From: Michael Eastham <Michael.Eastham@arun.gov.uk>
Sent: 15 May 2020 11:03
To: Planning.Responses <Planning.Responses@arun.gov.uk>
Subject: FW: Planning Consultation on BE/21/20/DOC - Salt Box

Subject: RE: Planning Consultation on BE/21/20/DOC

APPLICATION NO: BE/21/20/DOC

Site Address: Land At Salt Box West Of Shripney Road Bognor Regis PO22 9NW

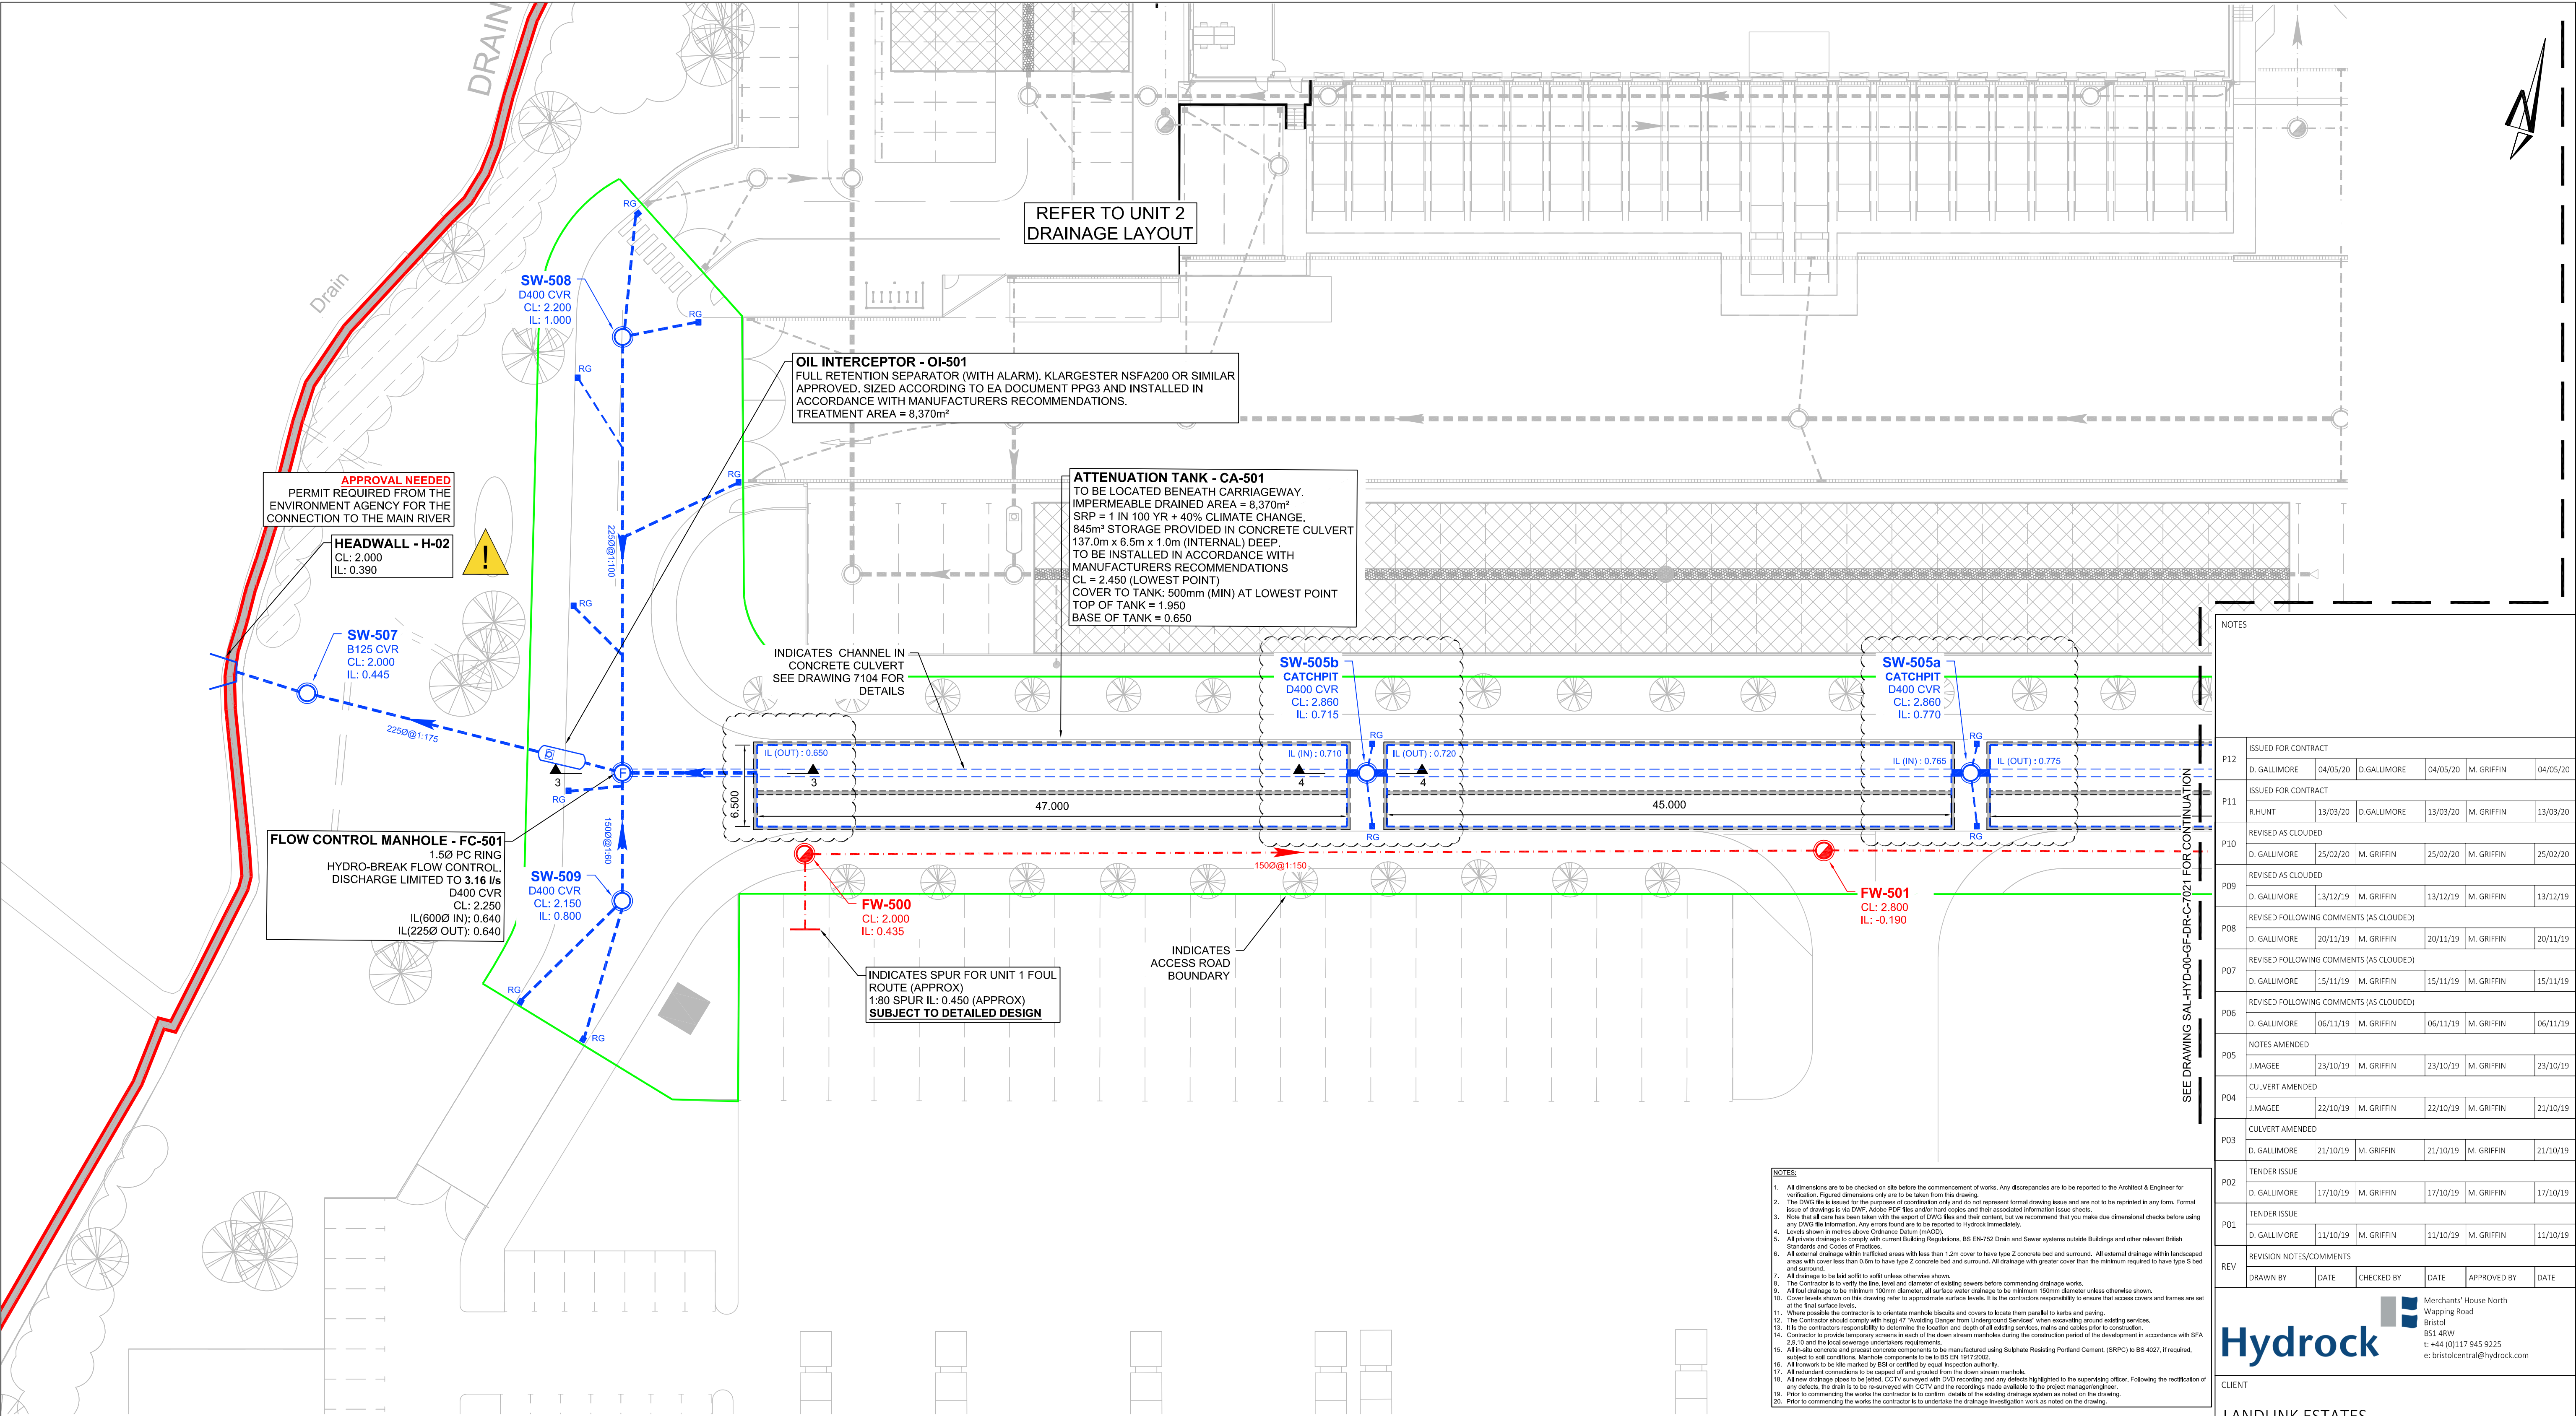
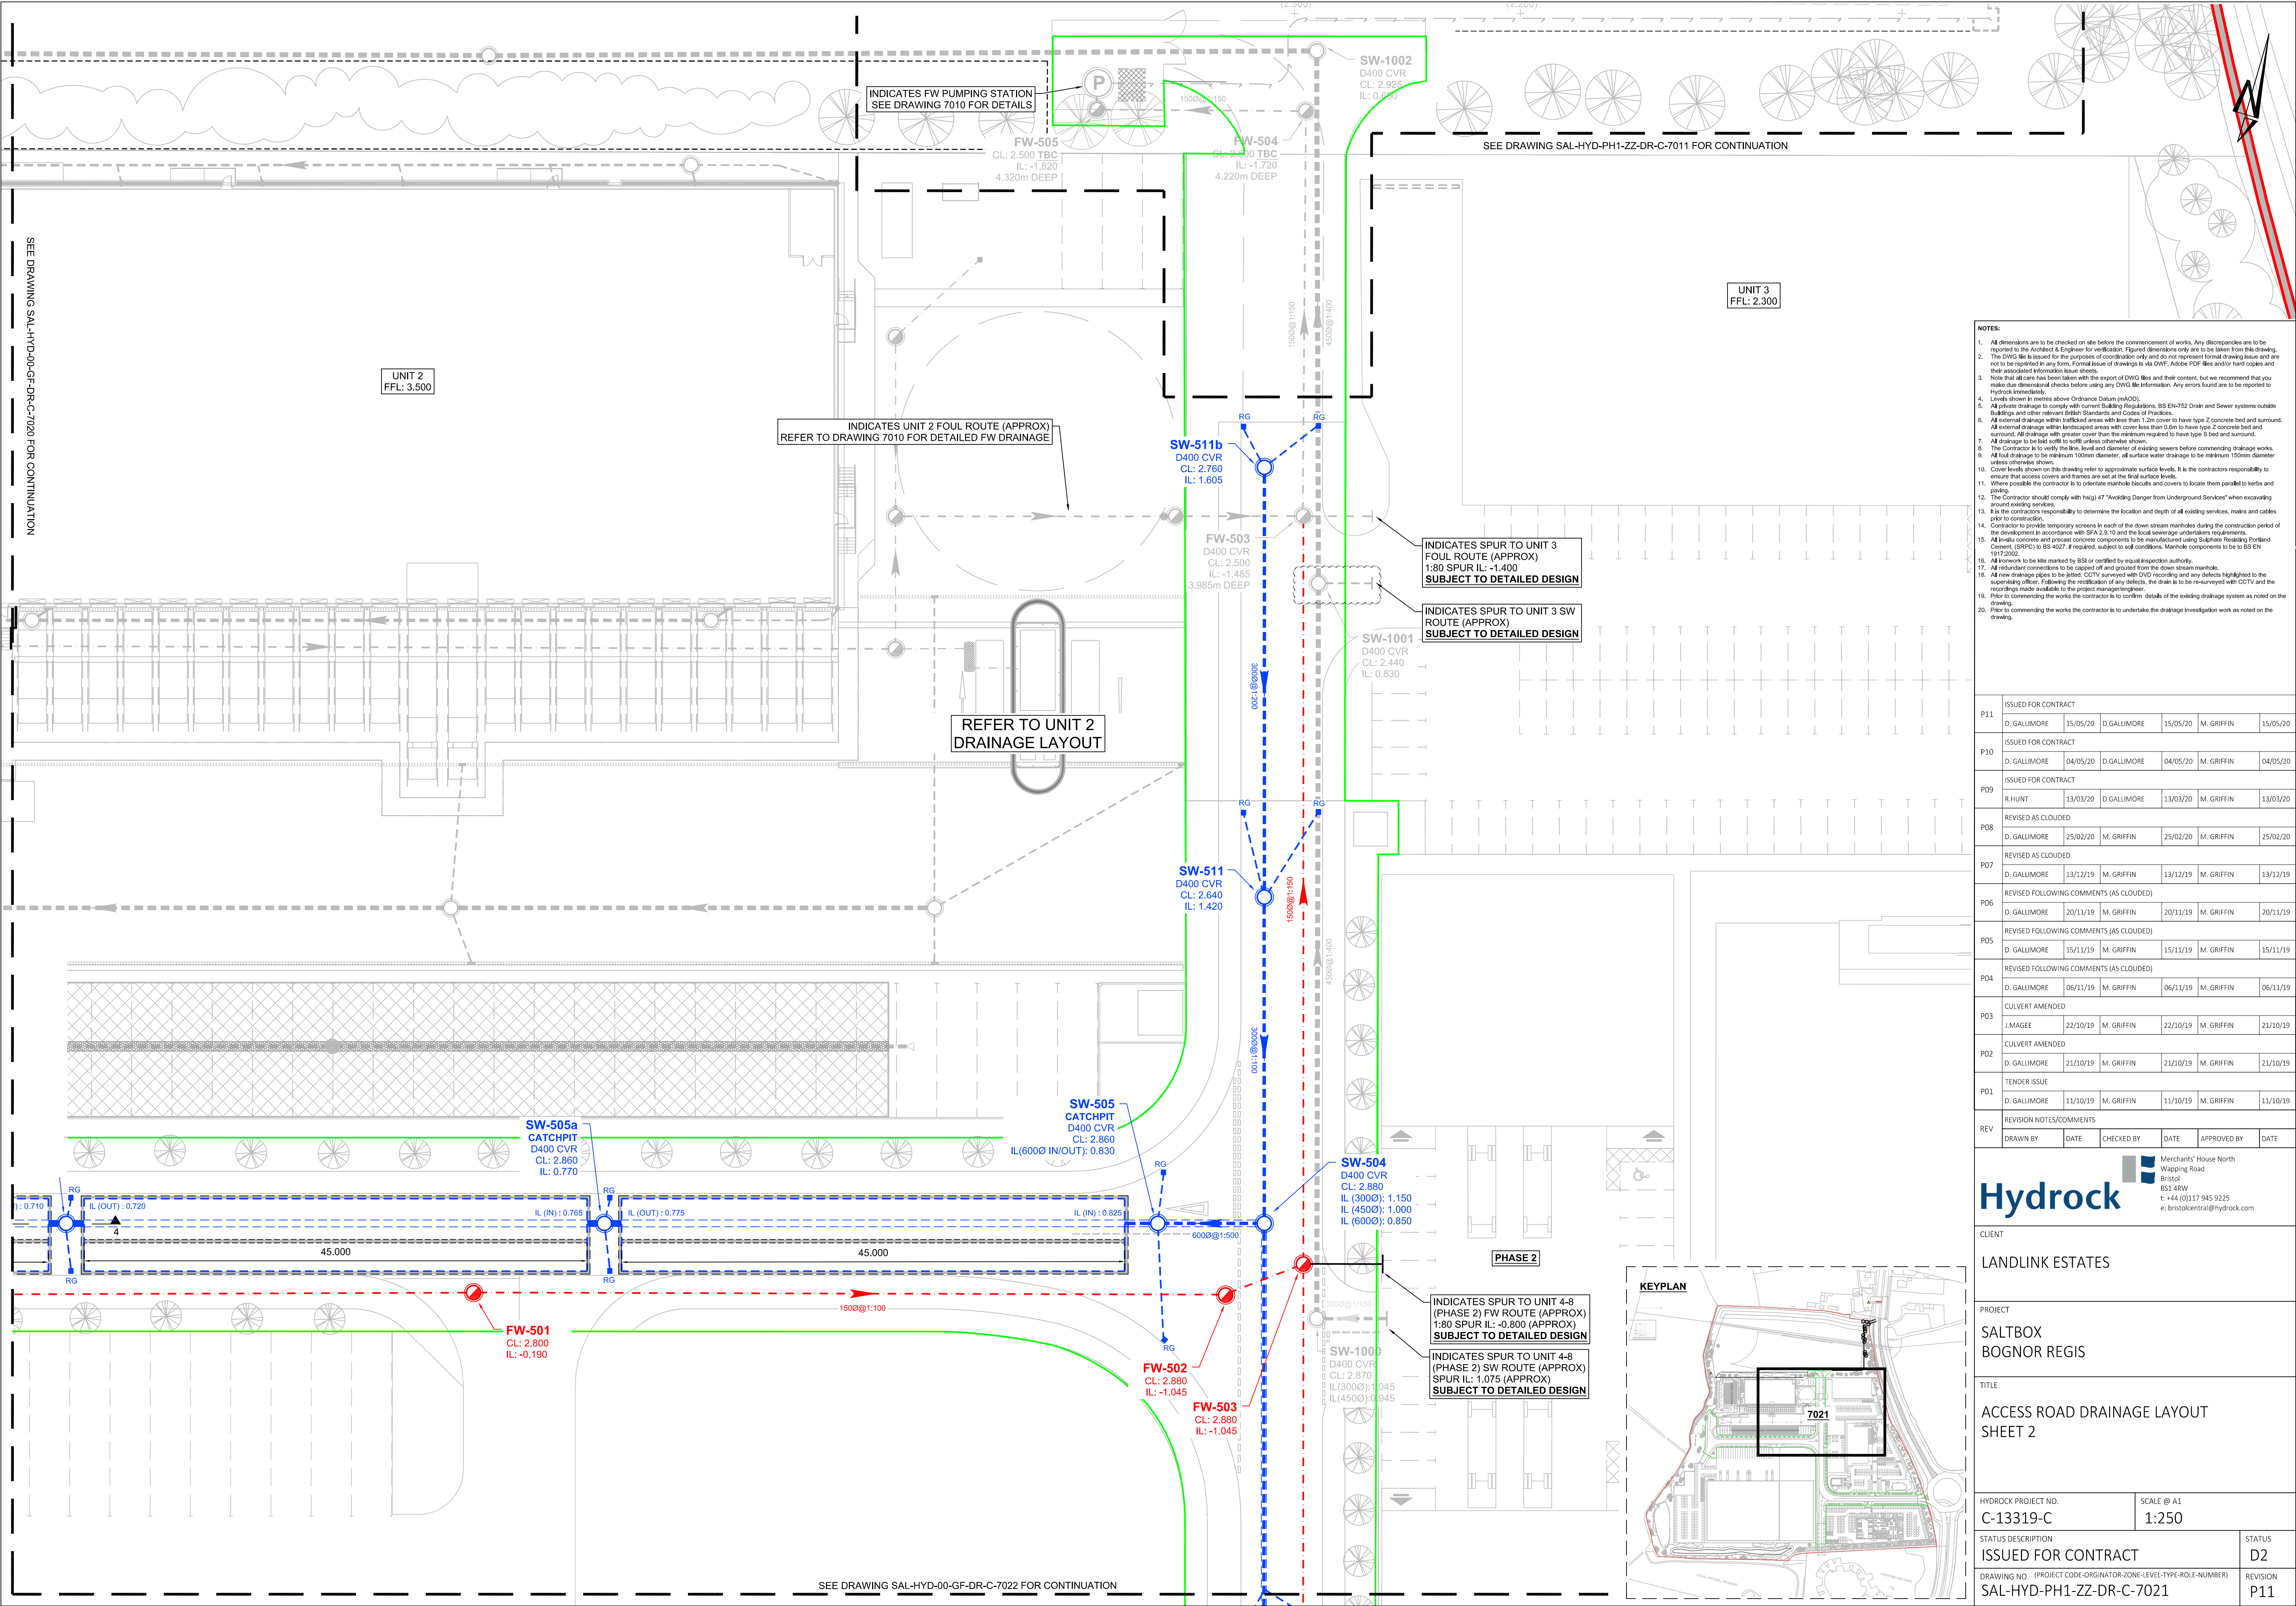
7. Manhole SW-900 invert level is different on plans 7011 and 7022. Noted.
PH1-7022 IL revised to suit PH2-7011. ok
8. Provide detailed headwall construction details for outfall no.3. This will also require Land Drainage Consent from myself since the connection is being made to an ordinary watercourse. See enclosed application form and guidance notes.
Phase 2 headwall detail added. Drawing 7111 noted, however, outfall has been labelled 2 rather than 3.
